Your Ref: OWPC17668
Our Ref: AW/55/18/HH
Please ask for:
Mr S Davis

Rear and side, single and two storey extension incorporating rear balcony. This application affects the Character & Appearance of the Aldwick Bay Conservation Area
3 The Orchard Aldwick

Decision: OBJECTION

PROPOSED ELEVATIONS

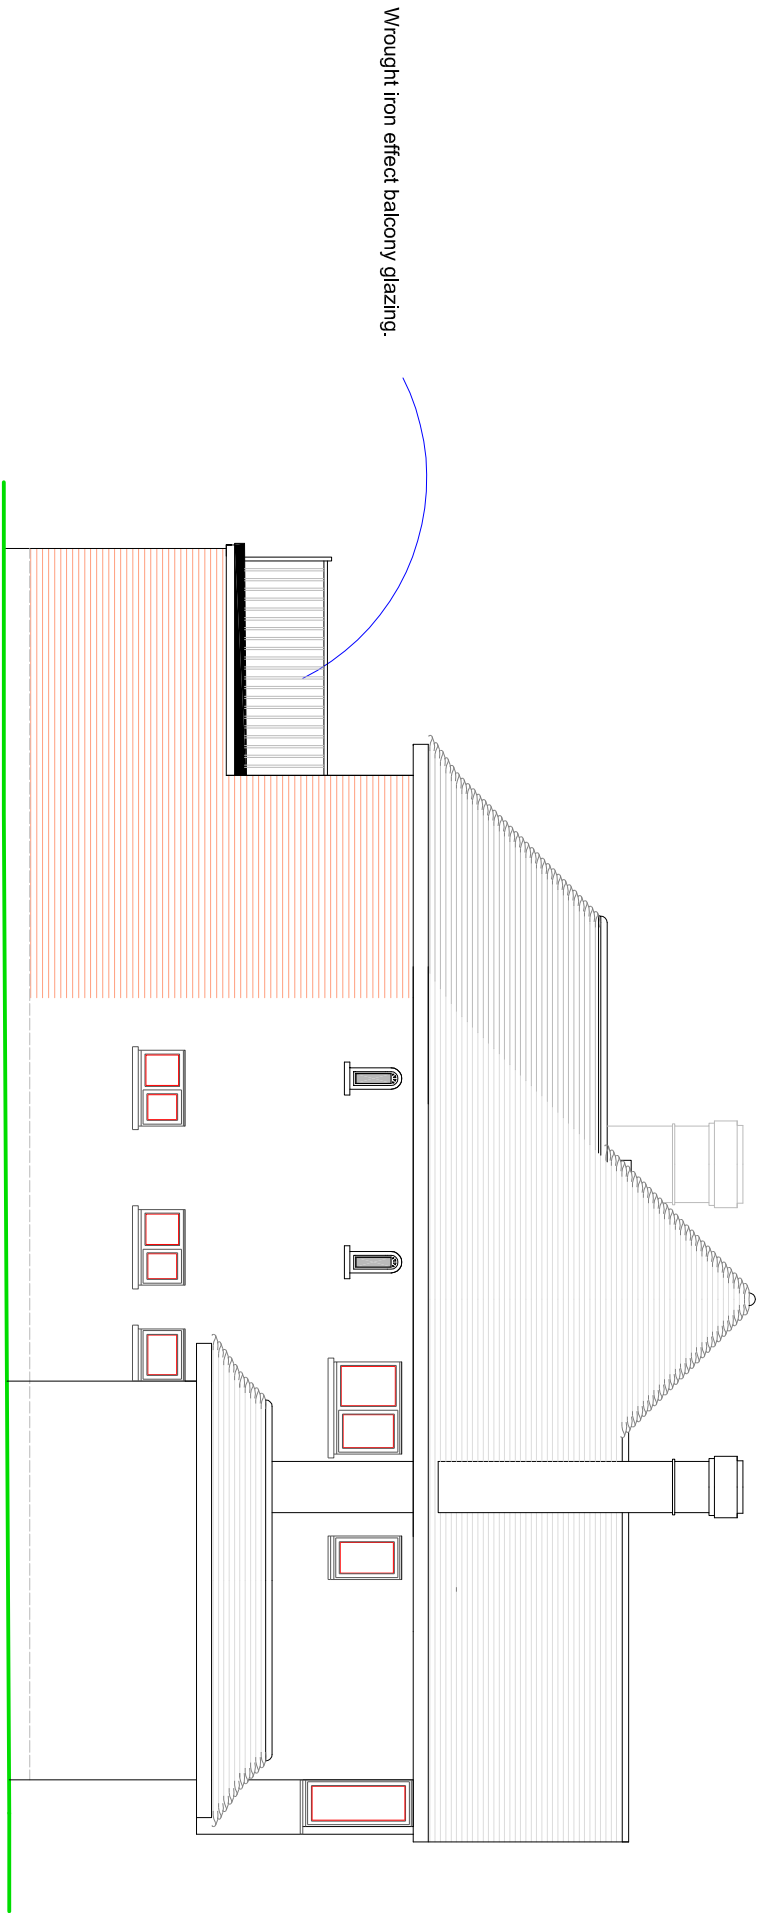
Members strongly objected to the application on the grounds that the proposed extension would not sympathetically relate to, nor be visually integrated with, the existing building in siting, design, form scale and materials and because it does not preserve or enhance a

Conservation Area. Therefore Members agreed that the proposed development is in direct opposition to Policy Dev 19 (i) of the Arun District Local Plan Dev 19 (i); and Policy Area 2 and the Parish Design Statement page 30. (The Ass't Clerk to inform the Ward Member of Members' decision)
